CITY OF ALBUQUERQUE

March 15, 2019

**Re: Maverik – 650 Juan Tabo NE
Erosion and Sediment Control Plan
Engineer's Stamp Date 1-18-19 (K22E059)**

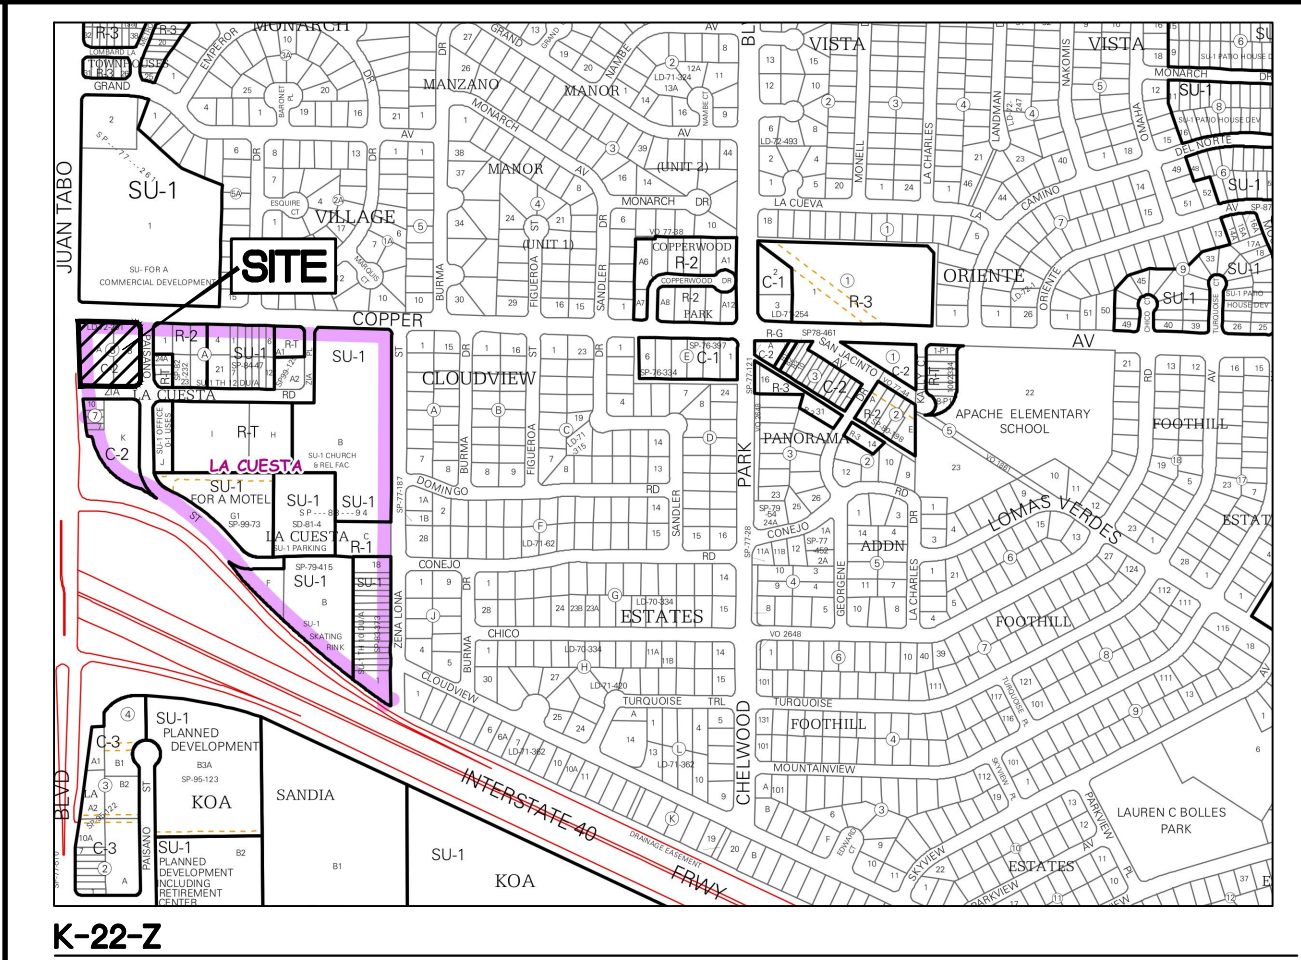
1. Provide existing grades.
2. Provide a BMP detail for the wattle. A detail is required for every BMP shown on the plan.
3. Silt fence is proposed on an impervious surface. It won't seal on the asphalt. A filter sock or similar is necessary at the toe of the silt fence.

Another way to approach this may be to use filter socks for the asphalt demo phase and silt fence once the asphalt has been removed. This can be shown on the plan using a standard legend with an accompanying note.

Filter/mulch socks work better than wattles as wattles do not let drainage pass through, whereas a filter/mulch sock will. Wattles will cause drainage to pond for a longer period of time which may cause the site to be muddy.

4. There is a line type for "Boundary Line". This line type is usually used for the property line. Project Boundary/Limits of Disturbance should be shown on the plan. It seems the Project Boundary/ Limits of Disturbance should align with the proposed silt fence on the west side of the project. The purpose of the "Boundary Line" shown in the middle of the project is not clear for erosion and sediment control purposes.

5. There is a note to "Provide positive drainage to sediment basin during all grading operations" in the northwest corner of the site. Prior to curbs being constructed, it appears most of the site will not drain to the pond.
